Table 1 – Response to Submissions Received During Exhibition

Note: The Responses to Submissions Received during Exhibition have addressed the modified Project Application as they apply to the amended site area.

ROAD PROFILE 6

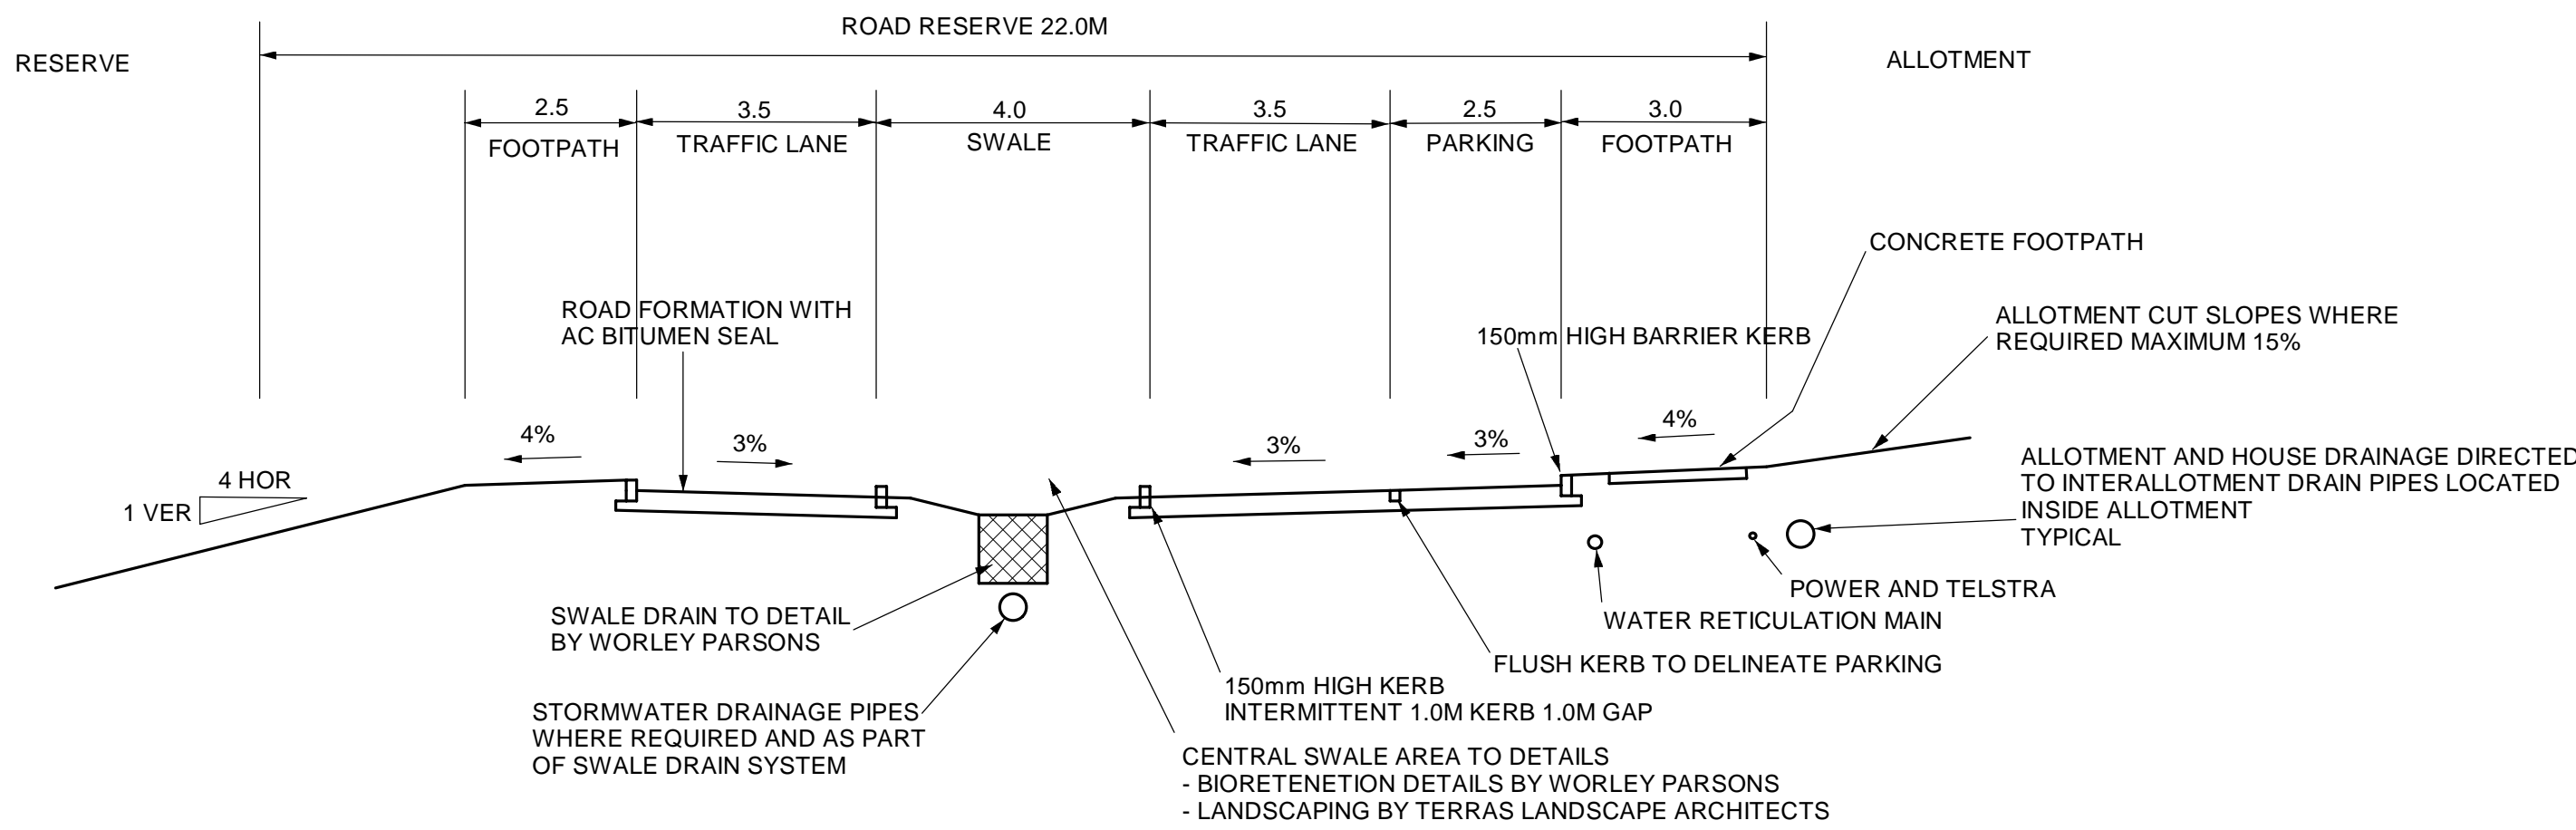
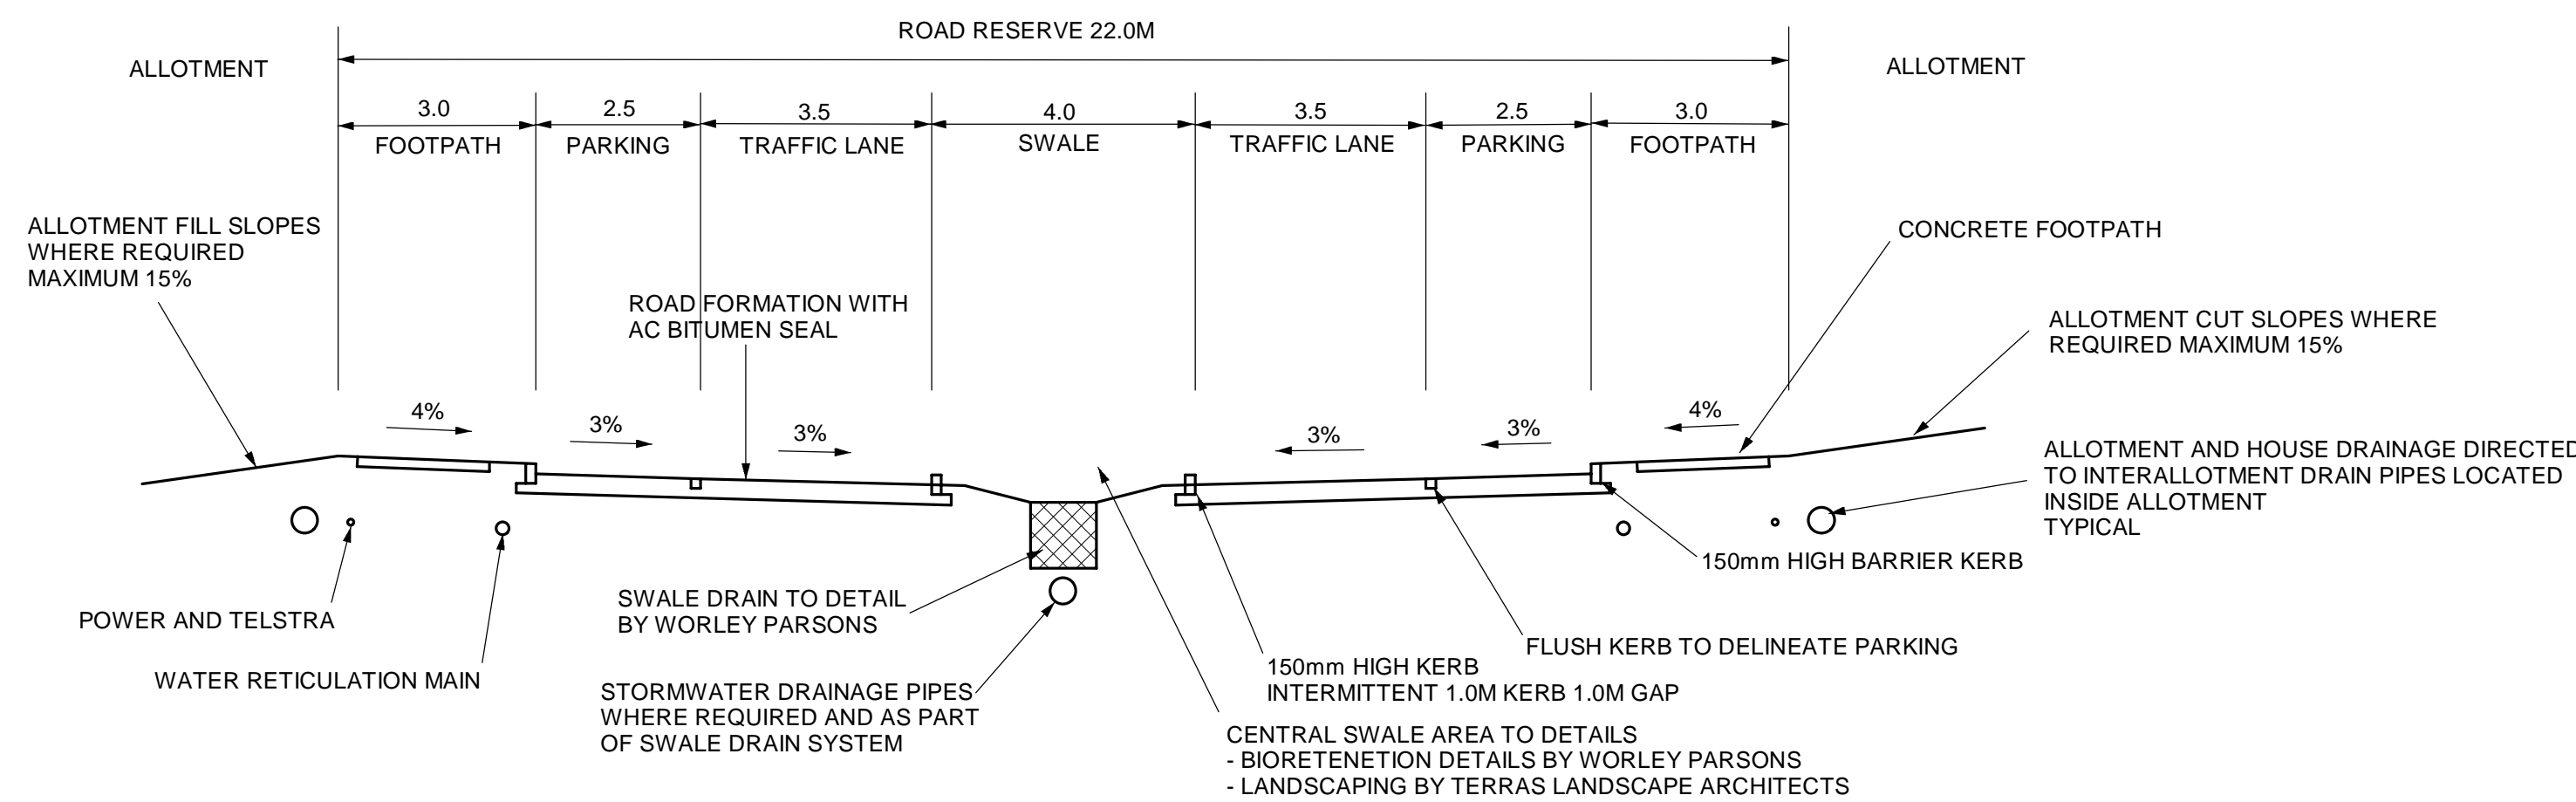
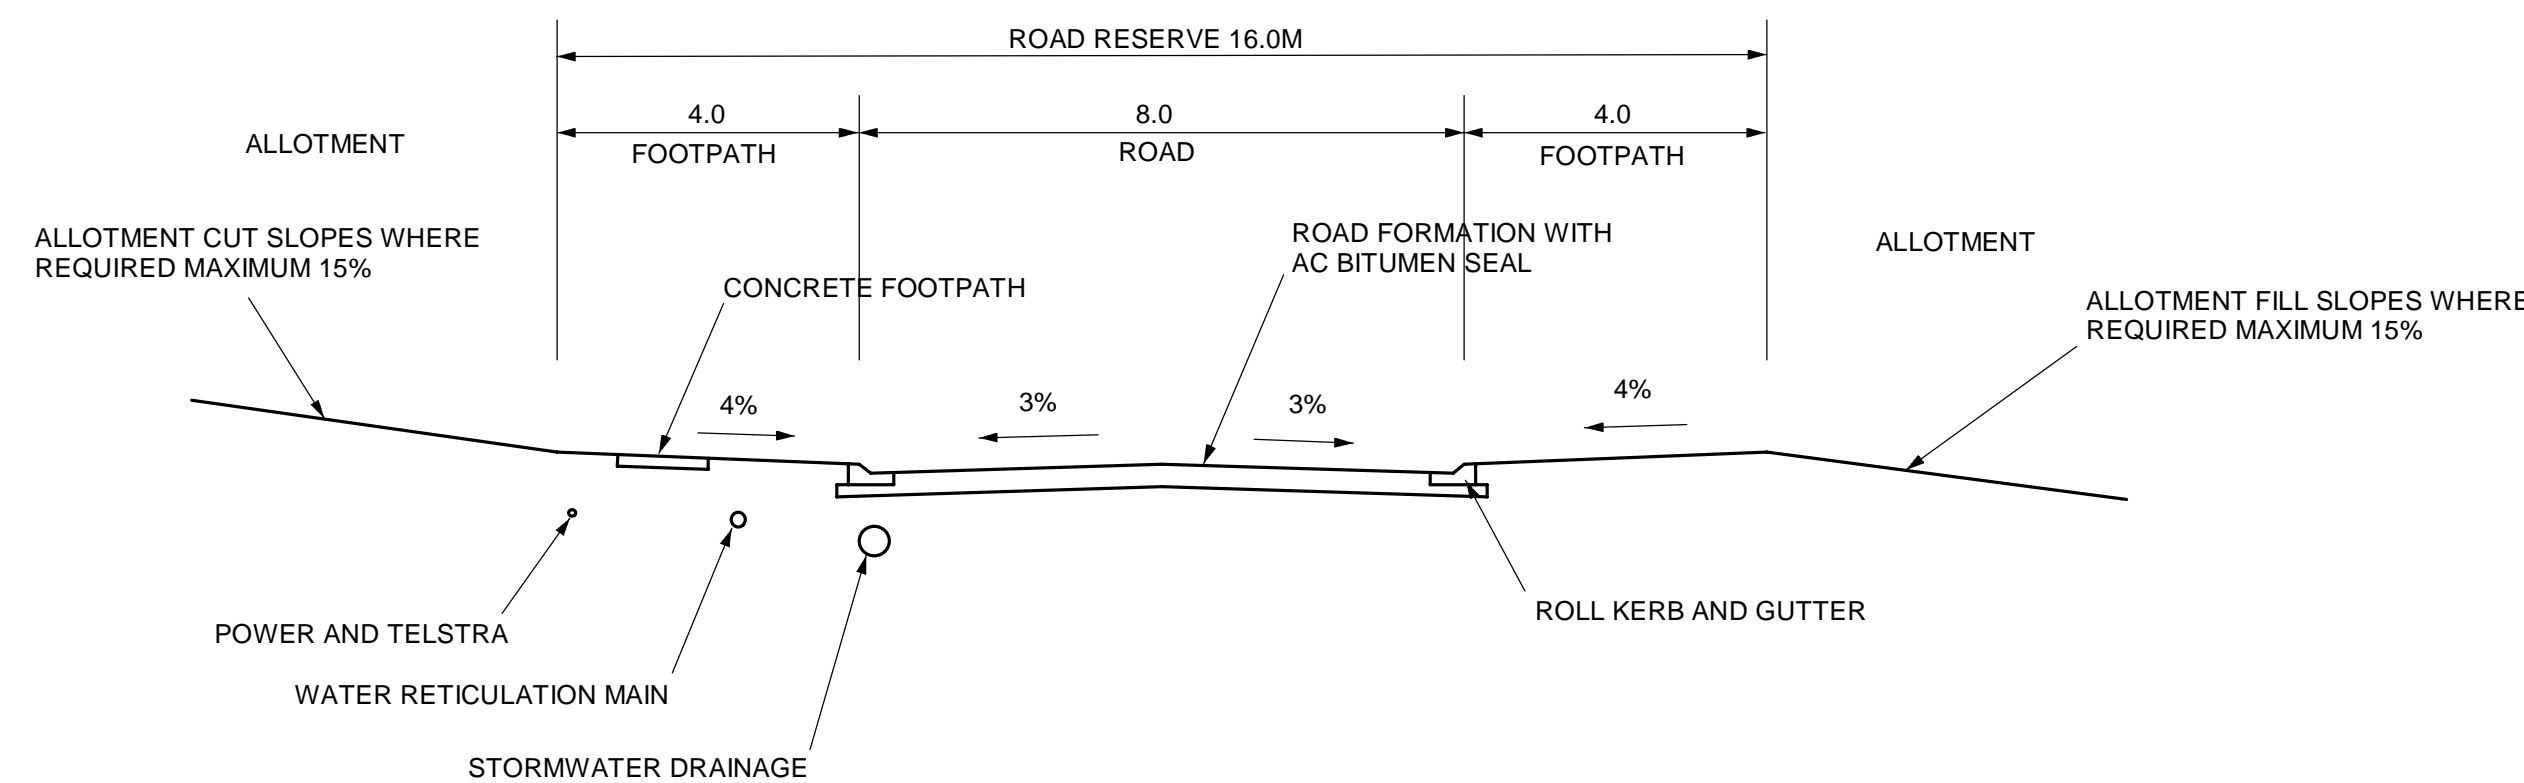
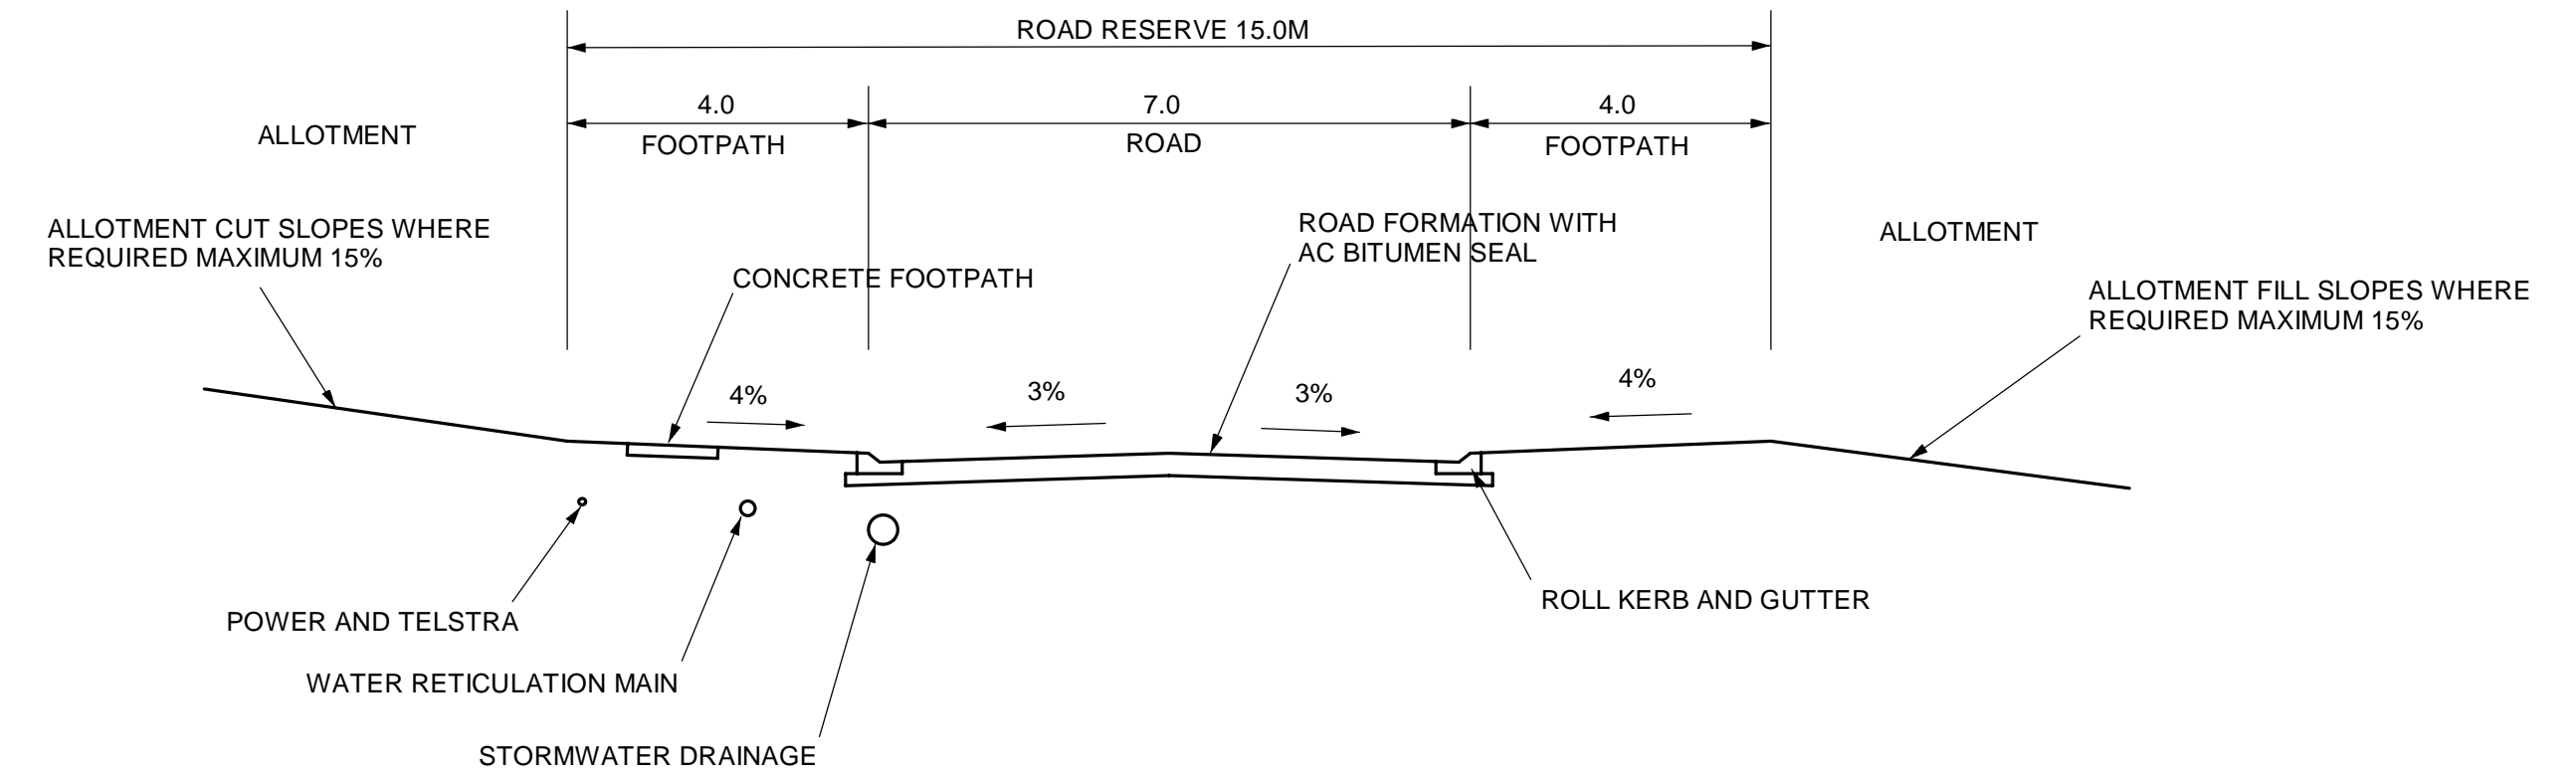
<ul style="list-style-type: none"> Road profile number 7 indicates that the perimeter road has a proposed carriageway width of 7 metres. The requirement is 8 metres similar to proposed Roads 5 & 6; 	Road Profile number 7 has been increased to be 8 metres in width.	No
	<ul style="list-style-type: none"> Suitable turning provisions shall be provided at the eastern end of Road 8; 	The redesign of the subdivision layout has incorporated the requirement for cul-de-sacs to have a 12m radius turning circle (24m diameter).	No
	<ul style="list-style-type: none"> Is the Road 8 loop road proposed as a one way road; 	The road layout has been amended to create a cul-de-sac (dead-end road) to the northern part of the site.	No
	<ul style="list-style-type: none"> The use of fire trails in the adjoining land to the east and south of the site 	The National Parks and Wildlife Service were consulted on	No
